TfNSW Reference: SYD21/00456/4

Bruce Zhang
Department of Planning and Environment
RE: SSD-17552047
Locked Bag 5022
PARRAMATTA NSW 2124

**WAREHOUSE & LOGISTICS HUB AMENDED INFORMATION
ALDINGTON ROAD ESTATE
155-217 ALDINGTON ROAD
KEMPS CREEK**

DRAWING TITLE
SITE ANALYSIS PLAN

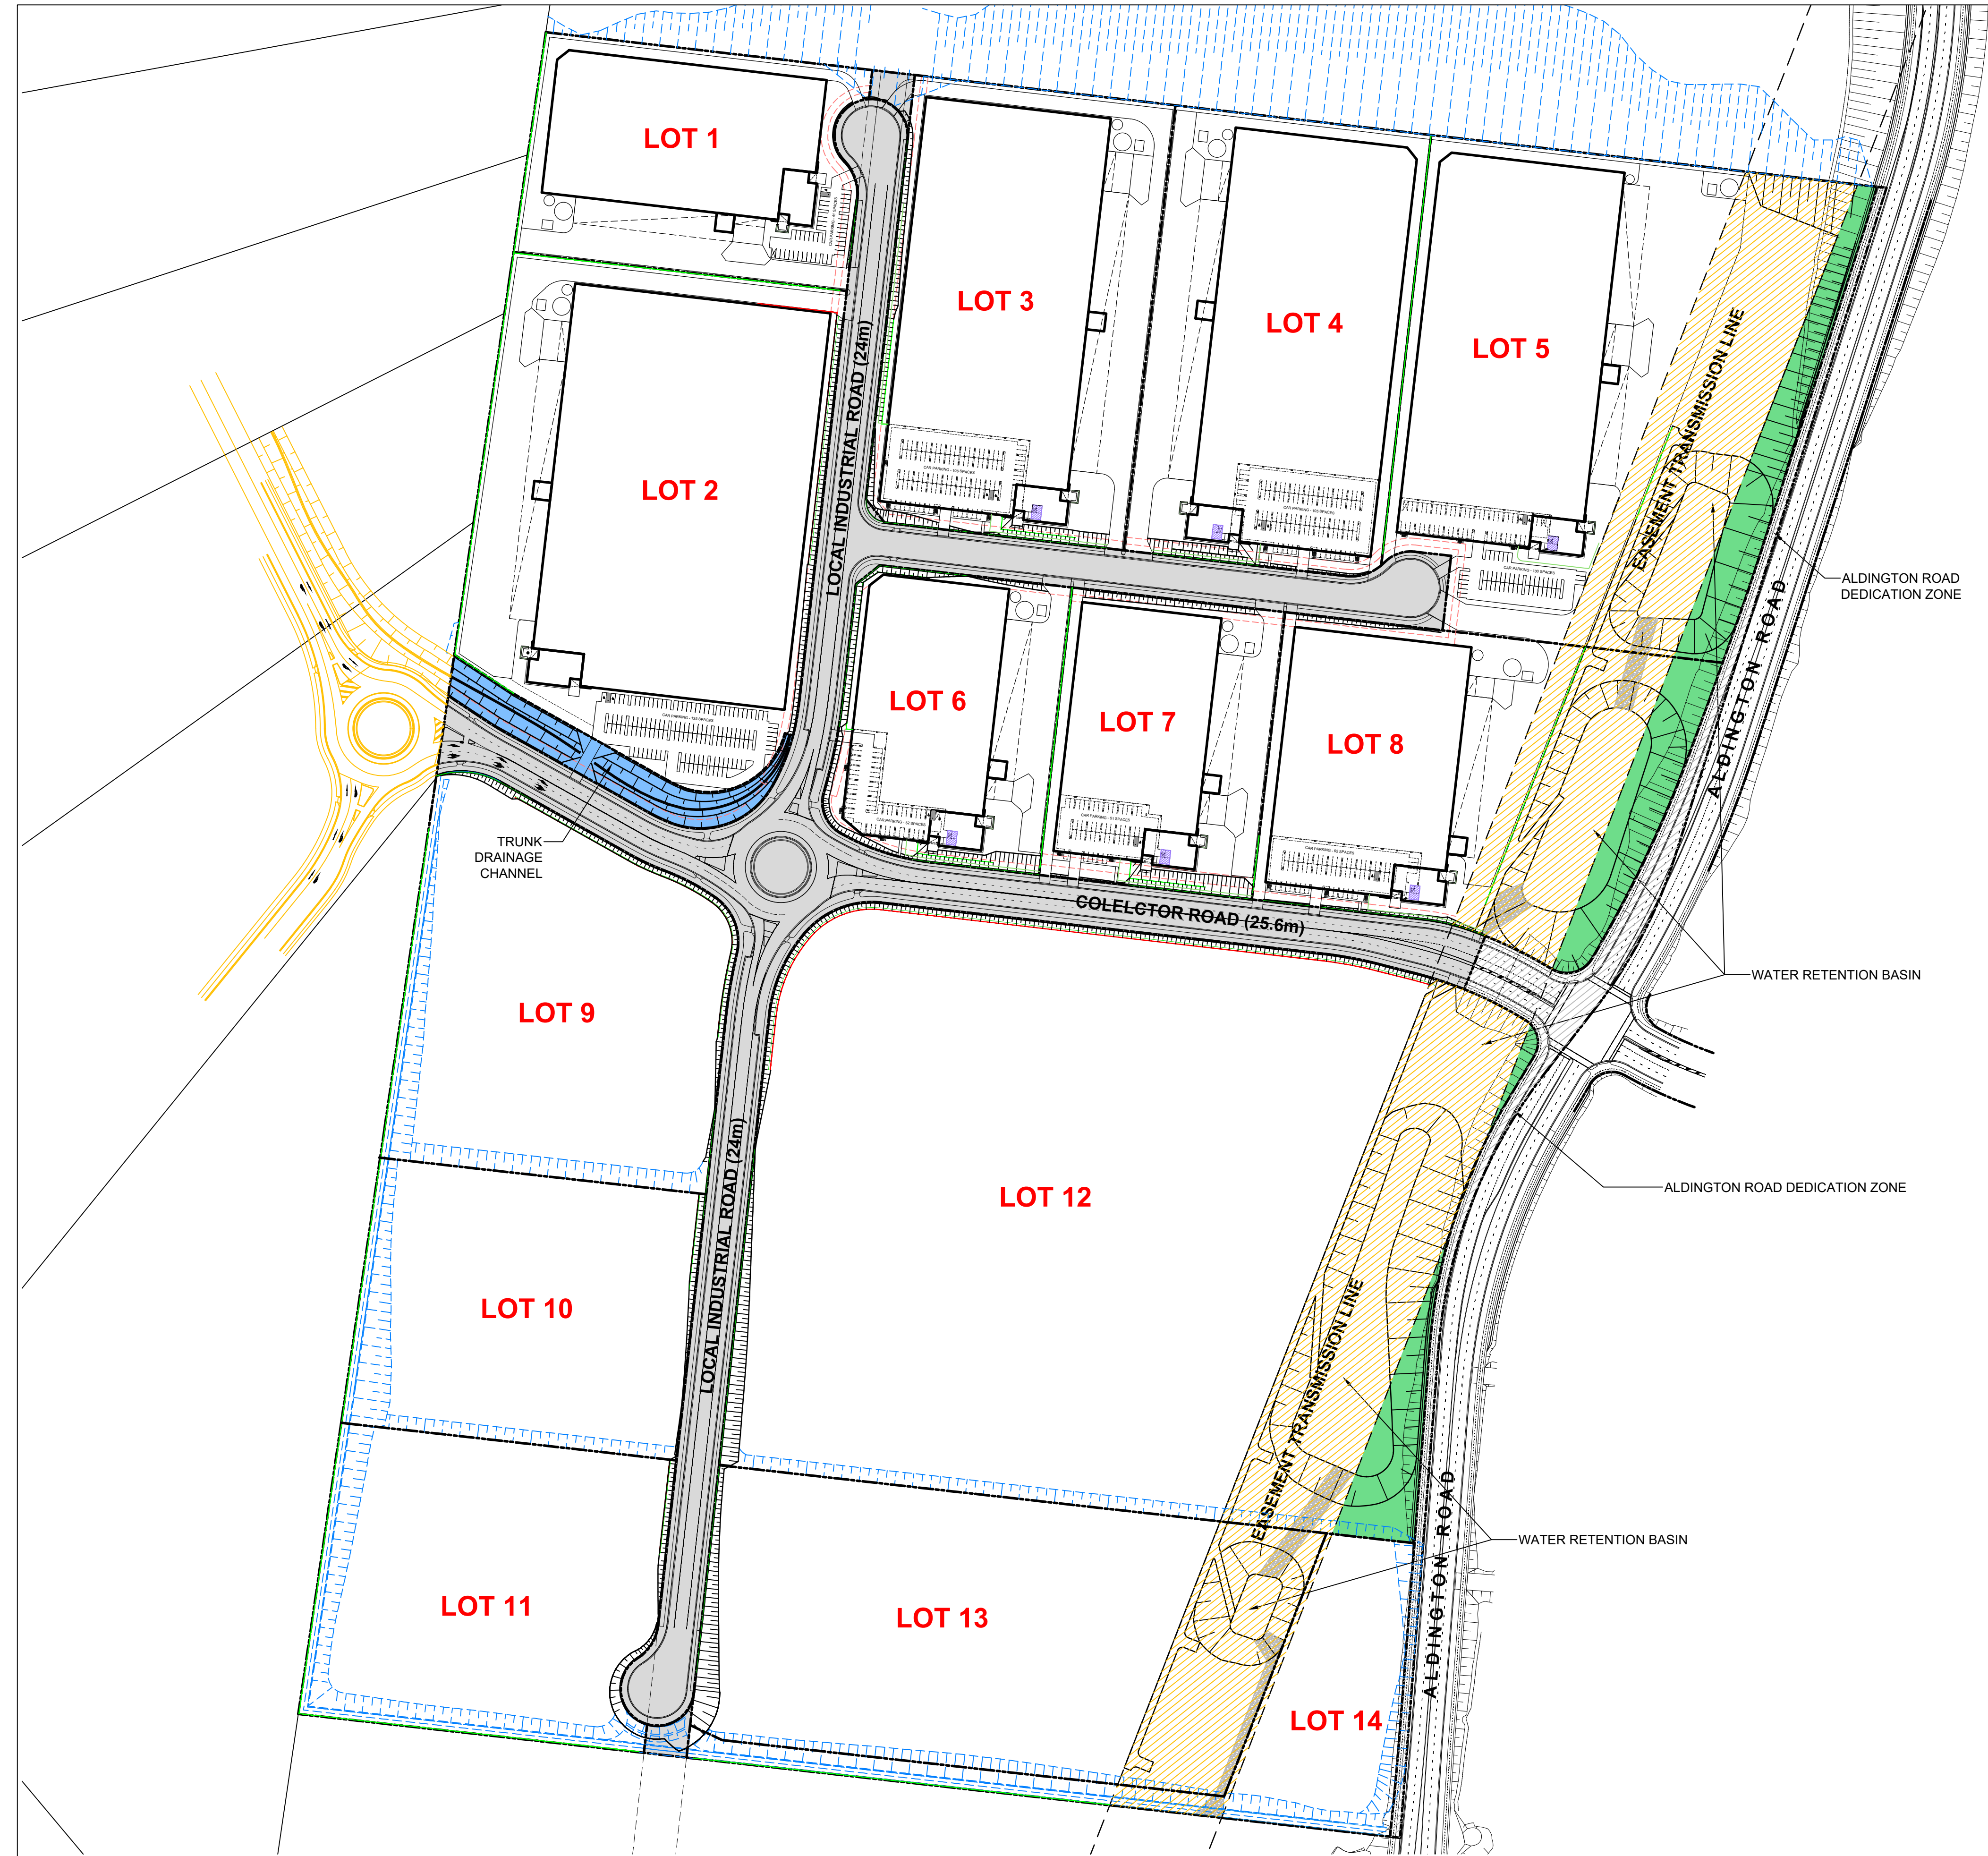
However, TfNSW is not supportive of the proposed access arrangements for lots 6, 7 and 8 noting the vehicular access to these lots is proposed via the collector road. TfNSW notes the revised layout, and the addition of the local industrial road (Road 3) would allow access to these lots from the local industrial road. To ensure traffic efficiency and road safety of the future collector road network, TfNSW requires that vehicular access to all proposed lots be provided via the local access roads.
